To: All Staff
From: Environmental Health
Date: February 10, 2026
Subject: VA-26-00001 Regan

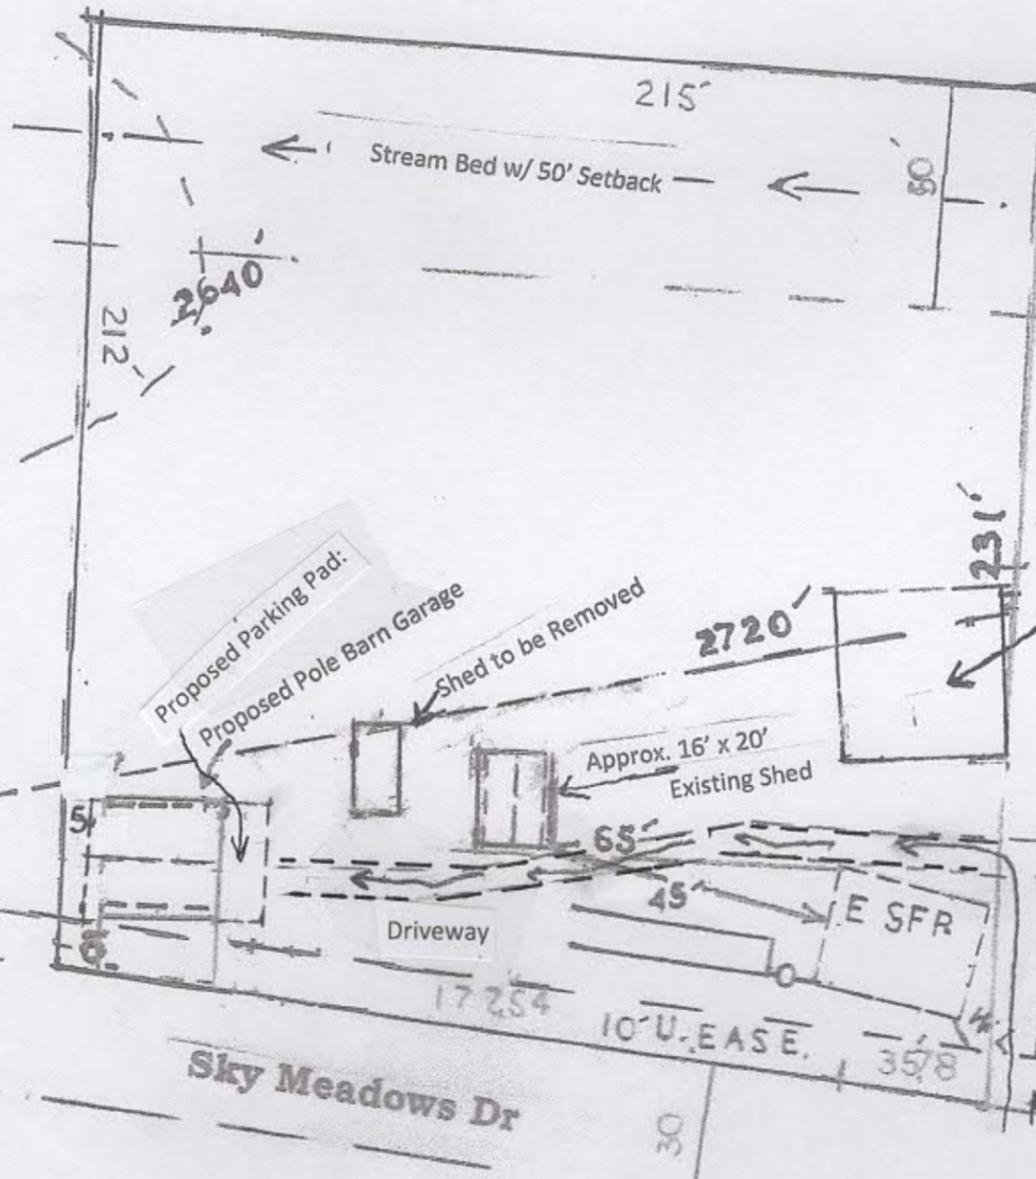
Drinking Water	<ul style="list-style-type: none">• No comment for dry structure
Wastewater	<ul style="list-style-type: none">• Building foundation setback five feet from septic tank, five feet from property line / easement, and ten feet from drain field
